ENG-SP20003-R3-PrelimPlan-redlines.pdf Markup Summary

1

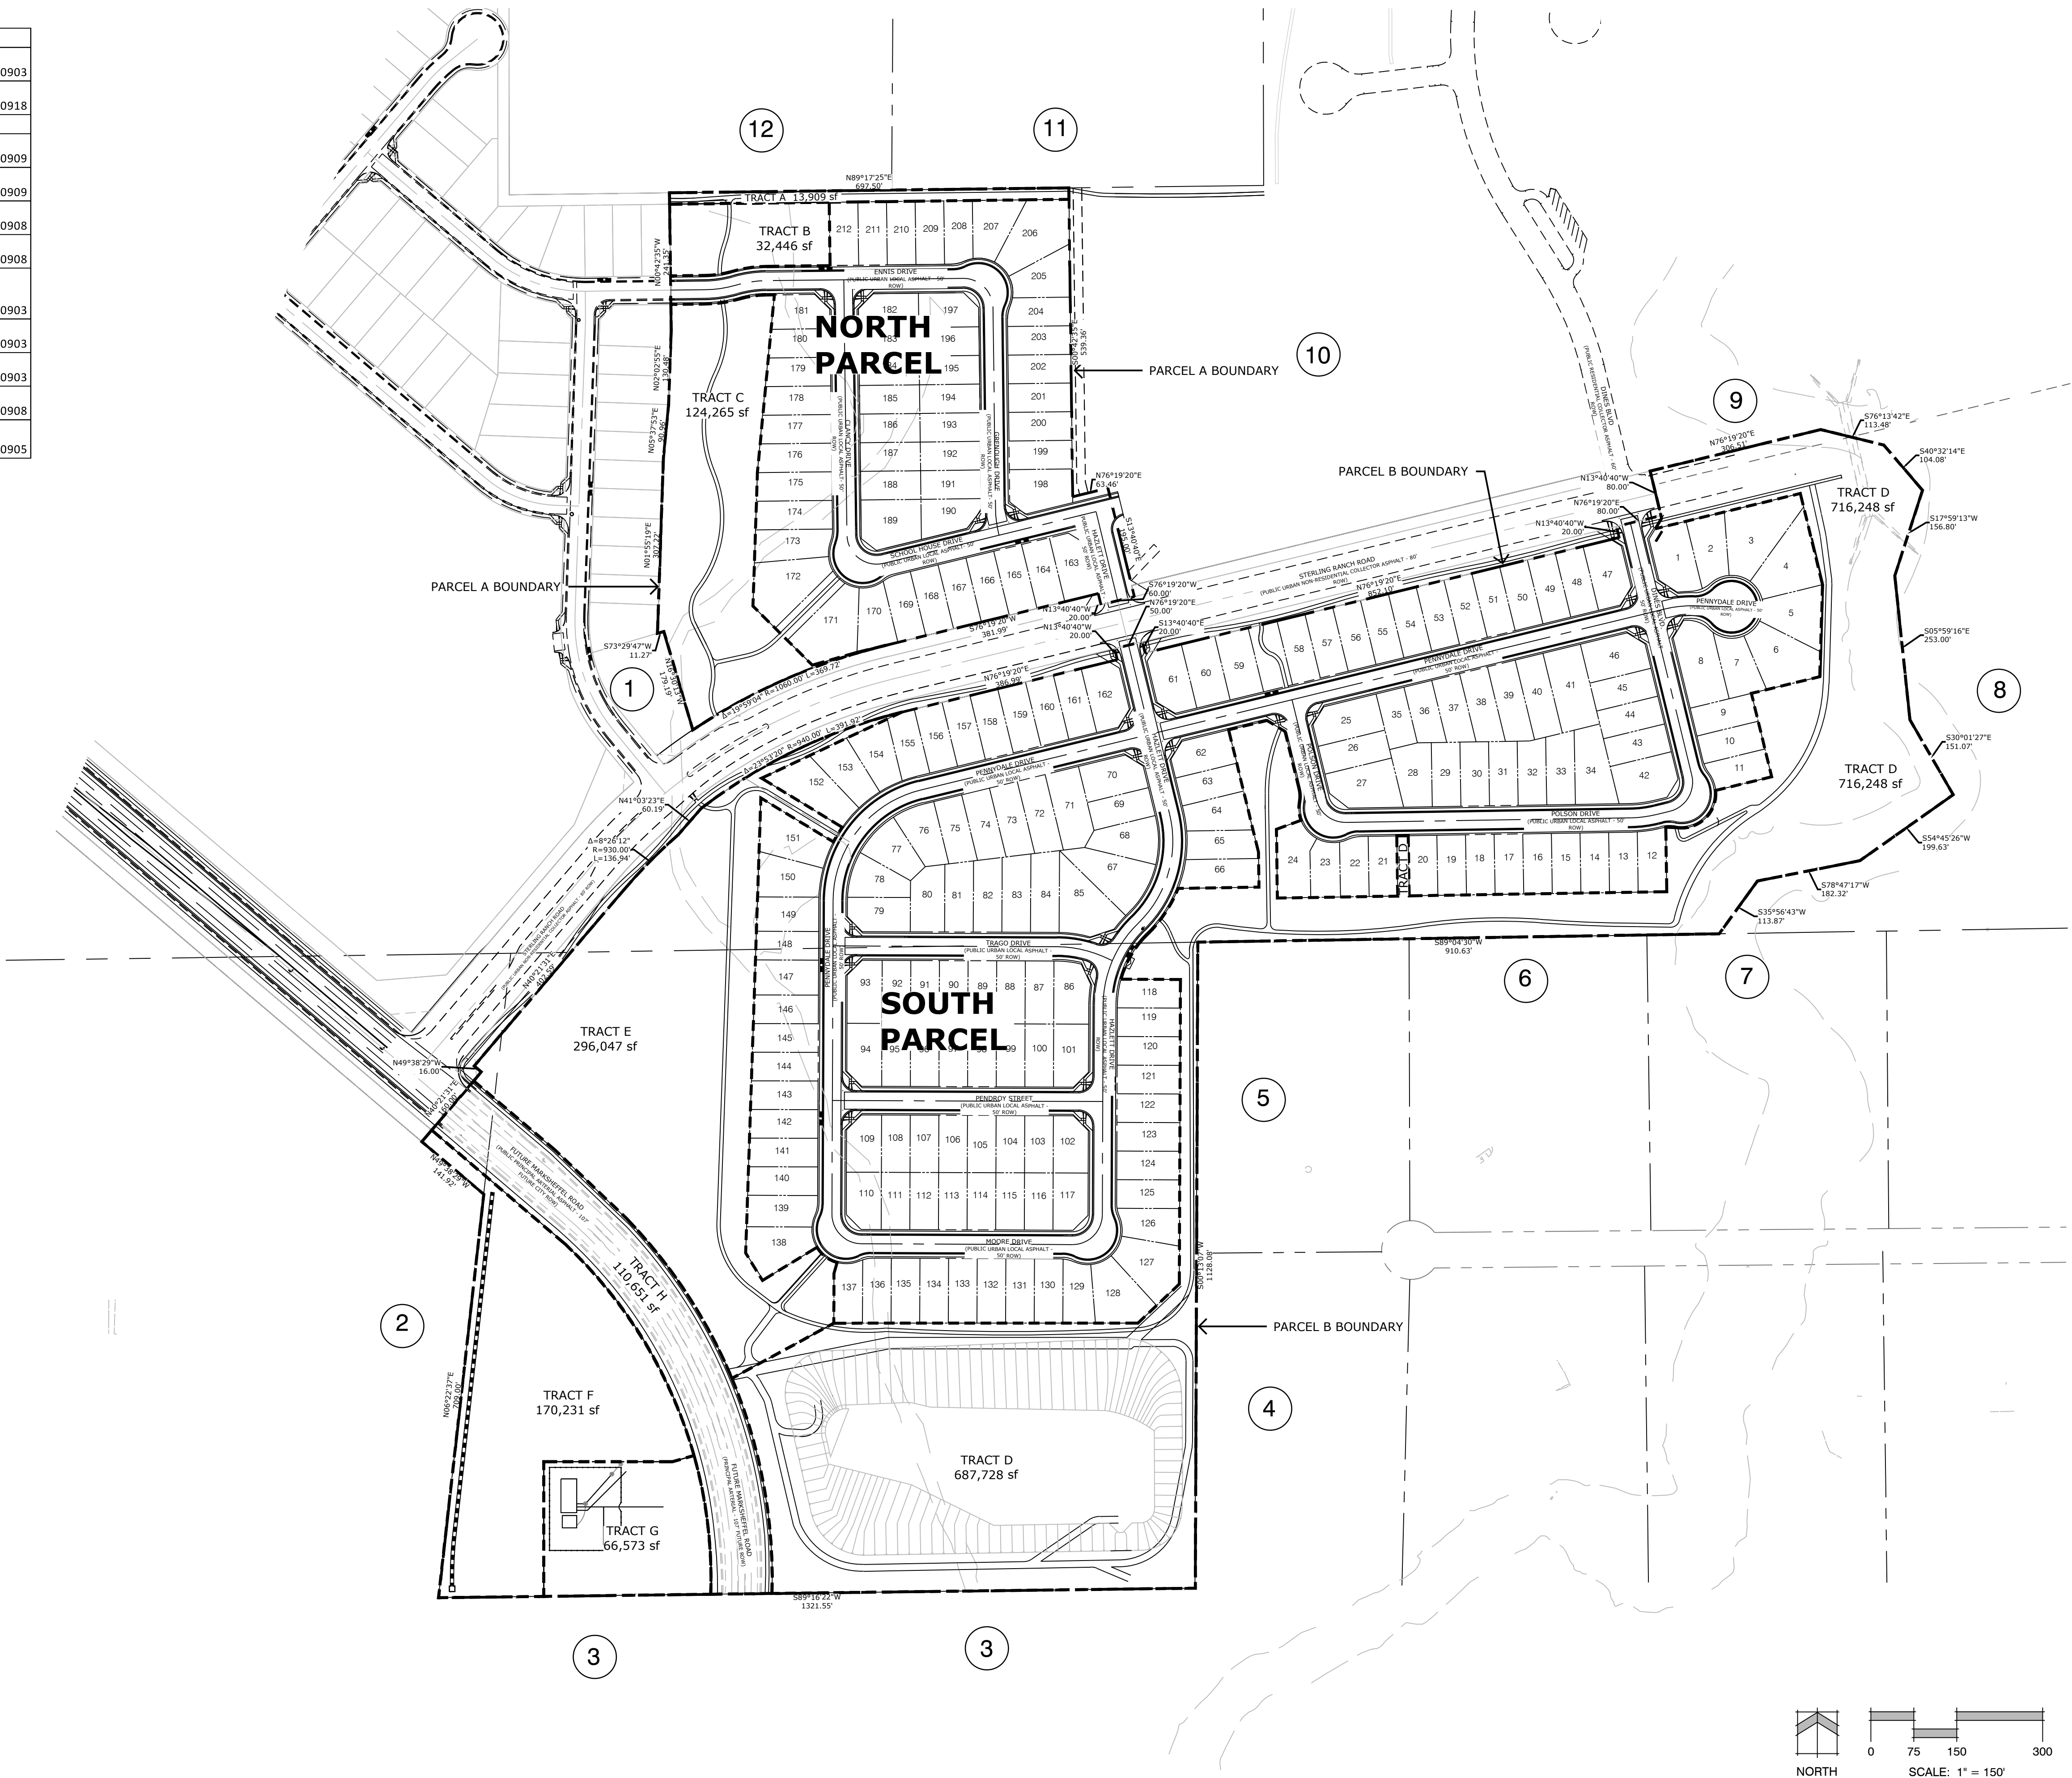
Subject: Callout
Page Index: 1
Date: 3/30/2021 12:17:40 PM
Author: dsdparsons
Color: ■
Layer:
Space:
Page Label: [1] Cover Sheet 1

how will we get this average? first lots in get the 100-foot setback and the last lots in are at 200-foot setback? Please let us know with final plat submittal

Subject: Callout
Page Index: 1
Date: 3/31/2021 7:26:51 AM
Author: dsdparsons
Color: ■
Layer:
Space:
Page Label: [1] Cover Sheet 1

Incorporate CGS comments and staff comments on GEO sheet no. 17. Provide specific lot nos. impacted and mitigation to address PSW and SW-basements may not be feasible- drains are not intended to mitigate SW constraint rather PSW constraint- See CGS comments- more mitigation note details needed specific to impacted lots.

STERLING RANCH PHASE TWO PRELIMINARY PLAN

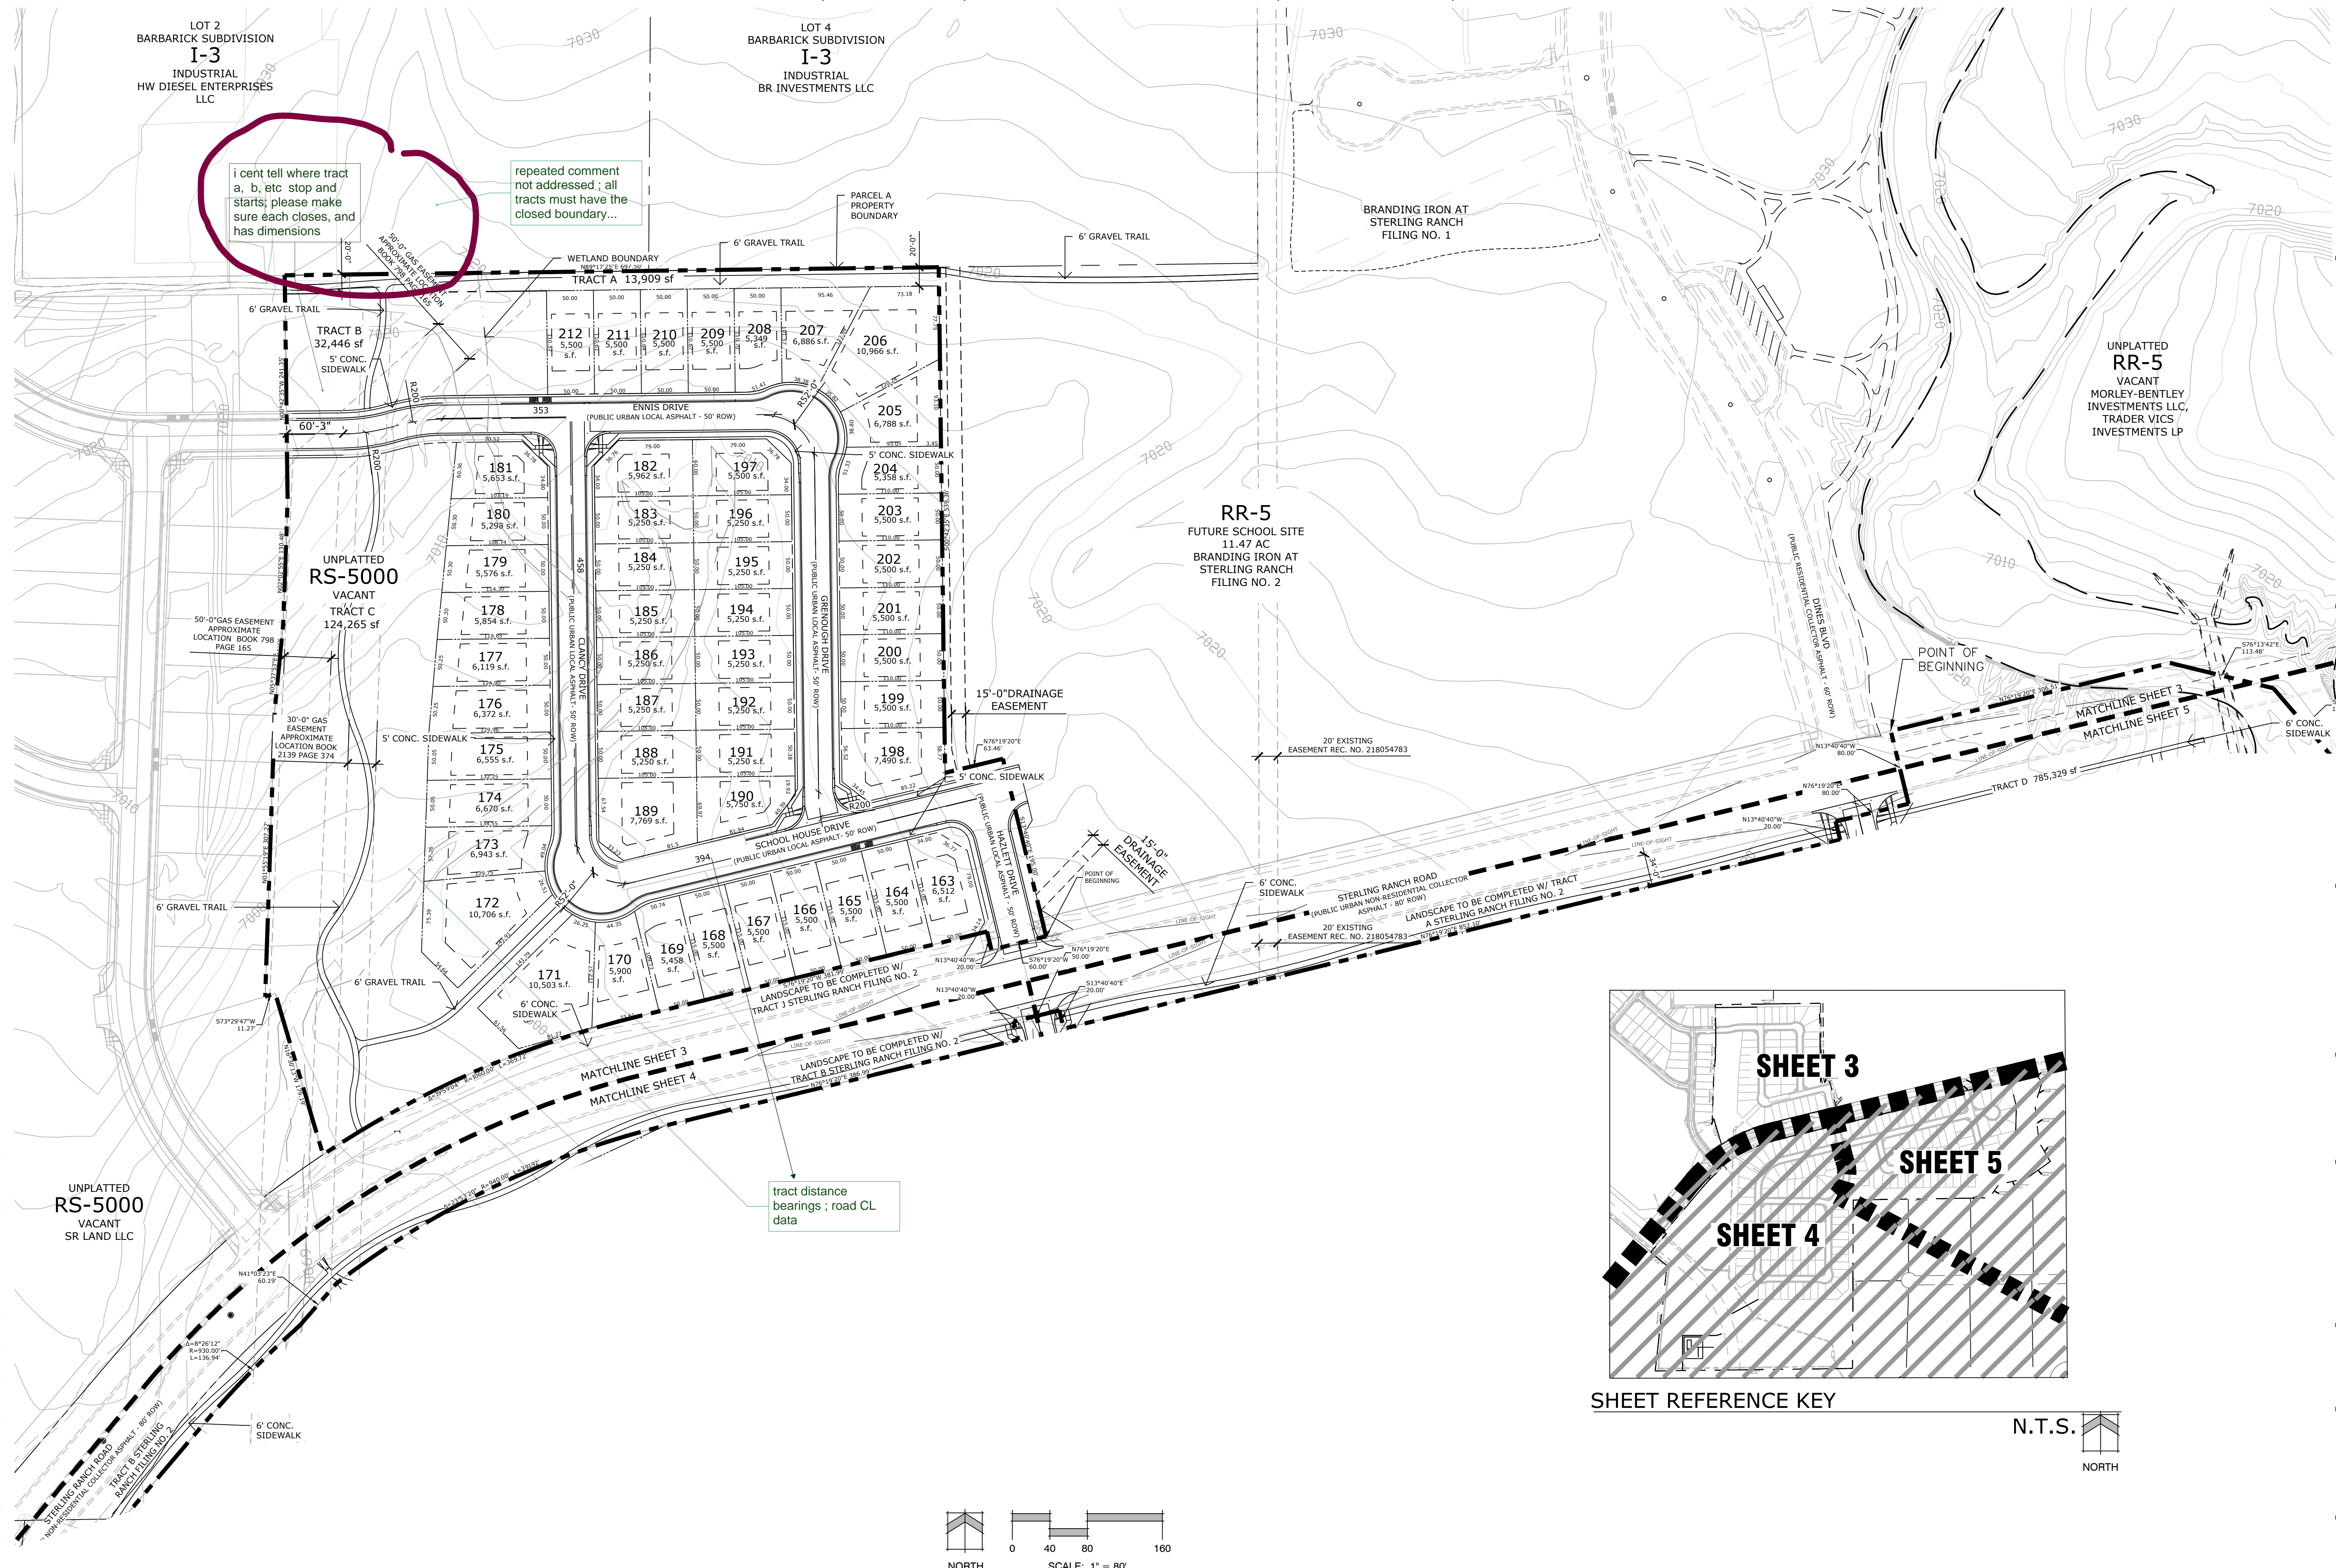
Subject: Callout
Page Index: 2
Date: 3/30/2021 1:04:47 PM
Author: dsdparsons
Color: ■
Layer:
Space:
Page Label: [1] Adjacent Property Owners Sheet 2

school site

Subject: Callout
Page Index: 2
Date: 3/30/2021 11:44:56 AM
Author: dsdparsons
Color: ■
Layer:
Space:
Page Label: [1] Adjacent Property Owners Sheet 2

future City ROW

Subject: Callout
Page Index: 2
Date: 3/30/2021 11:46:03 AM
Author: dsdparsons
Color: ■
Layer:
Space:
Page Label: [1] Adjacent Property Owners Sheet 2

distances and bearings should be on these tracts ; this is the tract sheet...

Subject: Callout
Page Index: 2
Date: 3/30/2021 12:21:56 PM
Author: dsdparsons
Color: ■
Layer:
Space:
Page Label: [1] Adjacent Property Owners Sheet 2

until City accepts Roadway

Subject: Callout
Page Index: 2
Date: 3/30/2021 2:16:37 PM
Author: dsdparsons
Color: ■
Layer:
Space:
Page Label: [1] Adjacent Property Owners Sheet 2

is this the school site? it dedicated ;owned by County

Subject: Callout
Page Index: 2
Date: 3/30/2021 2:51:46 PM
Author: dsdparsons
Color: ■
Layer:
Space:
Page Label: [1] Adjacent Property Owners Sheet 2

Future Passive Open Space- Park Site

Subject: Text Box
Page Index: 2
Date: 3/30/2021 3:07:31 PM
Author: dsdparsons
Color: ■
Layer:
Space:
Page Label: [1] Adjacent Property Owners Sheet 2

Sterling Ranch FIL 2 Plat =
 Marksheffel Road to Sterling Ranch Road

Subject: Callout
Page Index: 2
Date: 4/1/2021 7:36:51 AM
Author: dsdparsons
Color: ■
Layer:
Space:
Page Label: [1] Adjacent Property Owners Sheet 2

(existing now)?
